# BRADLEY POINT FILING NO. 1

# GRADING/EROSION CONTROL PLANS

# BRADLEY POINT FILING NO. 1

## GRADING AND EROSION CONTROL PLAN

GRADING AND EROSION CONTROL PLAN

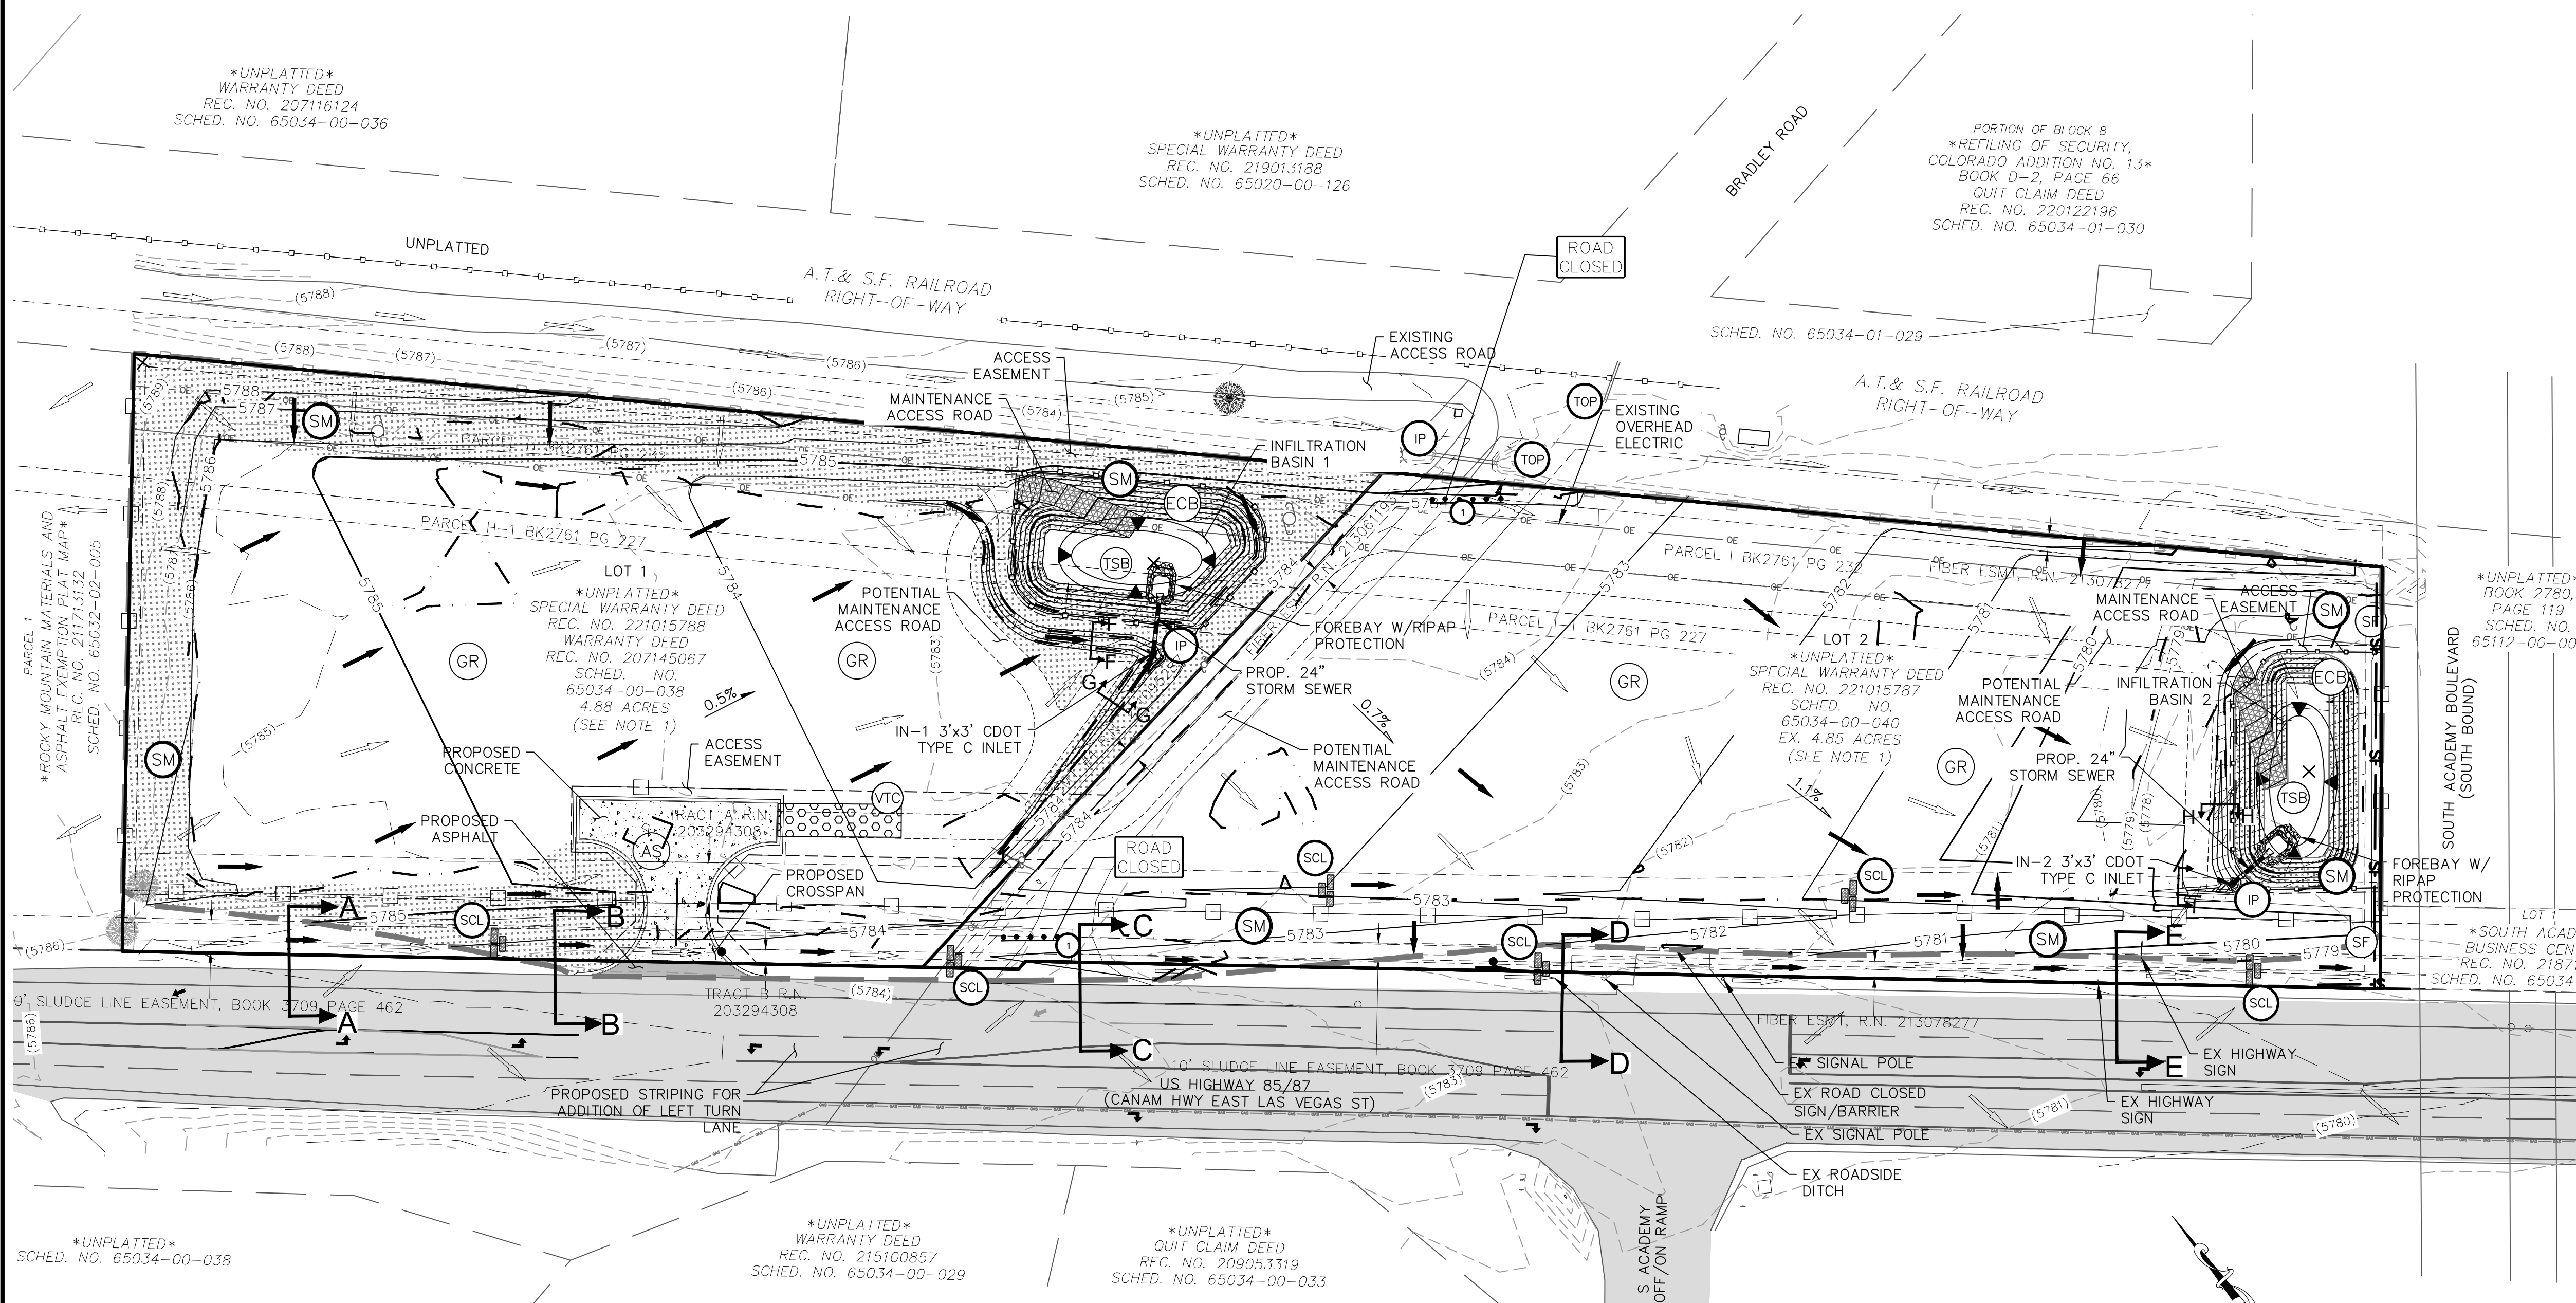
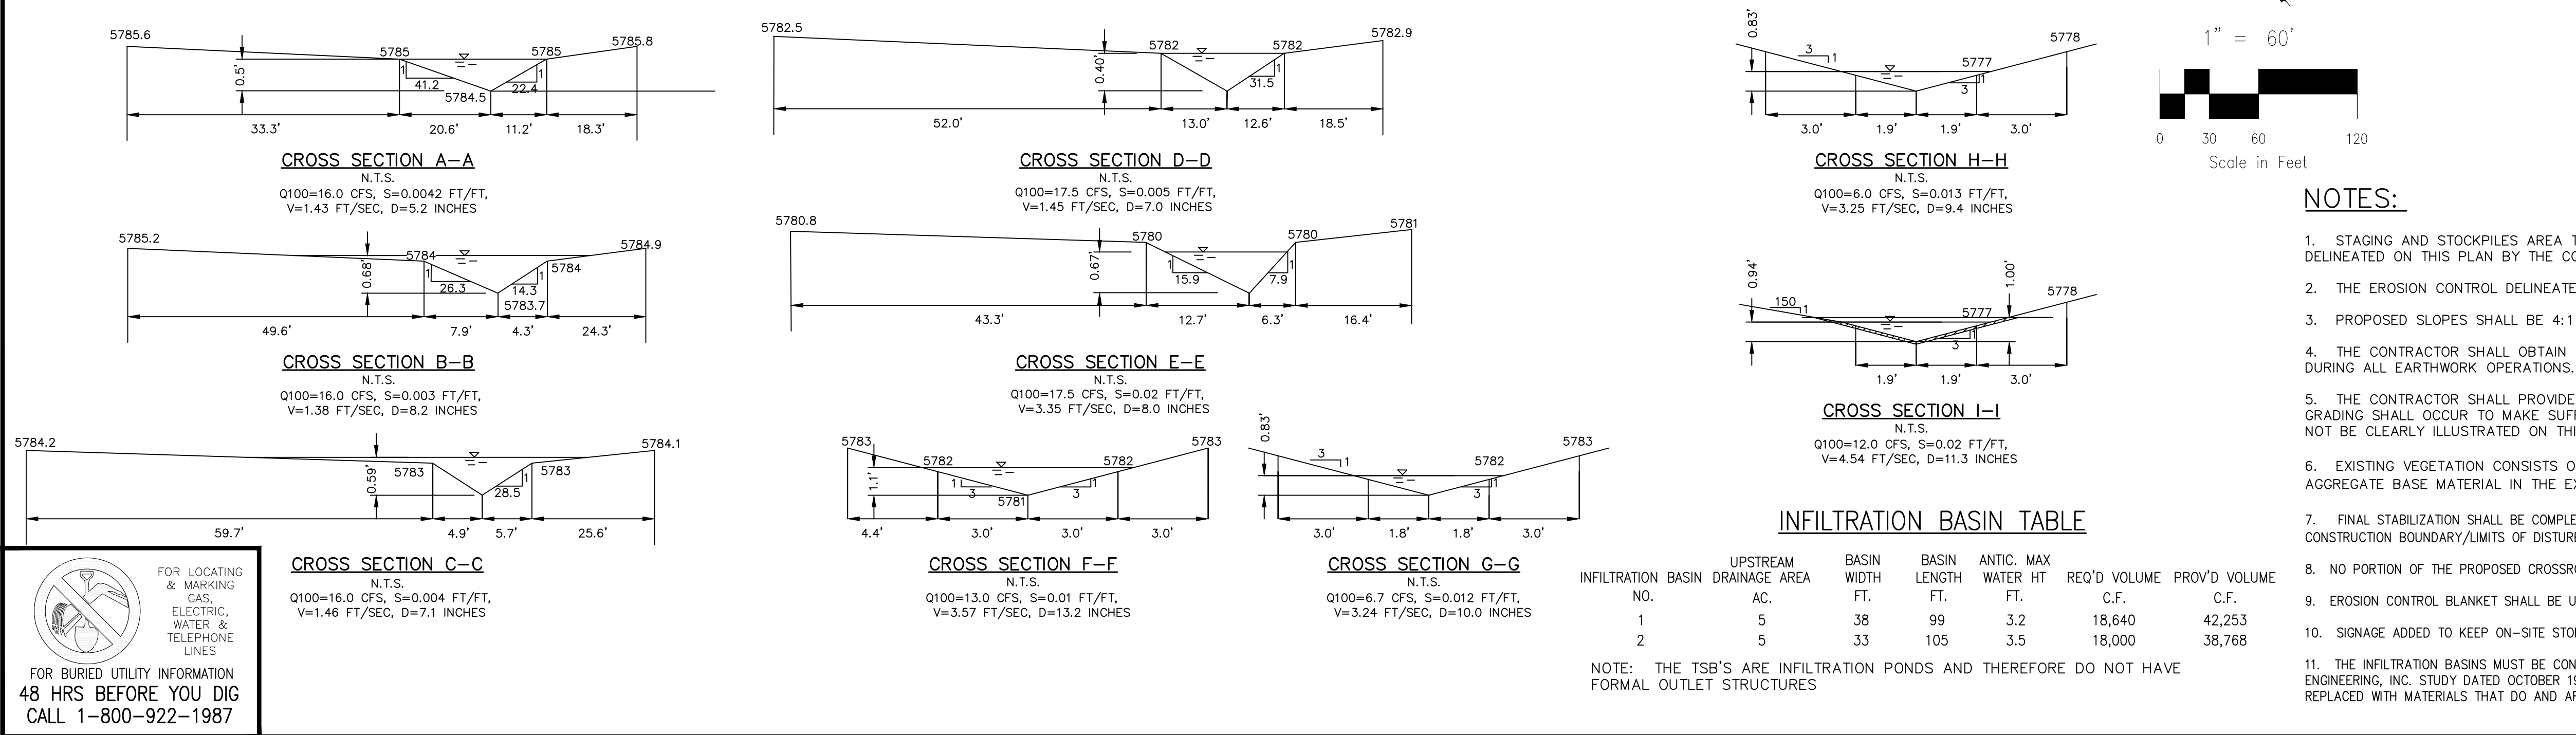
provide PLD/SFB?? details (maintenance road, outlet structure, spillway, forebay, riprap sizing, filter media, etc.)

show all areas to be seeded, gravel, and asphalt

Show construction boundaries. If "limits of disturbance" and "construction boundary" are the same, change to "limits of construction/disturbance" or otherwise show as separate line types for each on the legend and figure.

Call out as Porous Landscape Detention (PLDs) or Sand Filter Basins (SFBs)??

Label PLD/SFB?? IDs on figure

For sites where full infiltration is proposed, an on-site infiltration test using double-ring infiltrometer is required. Infiltration tests should be performed or supervised by a licensed professional engineer and conducted at a minimum depth equal to the bottom of the PLD. Underdrains and/or an outlet structure is required if infiltration tests show rates slower than 2 times that required to drain the WQCV over 12 hours.

include spillway size

NOTE: THE TSB'S ARE INFILTRATION PONDS AND THEREFORE DO NOT HAVE FORMAL OUTLET STRUCTURES
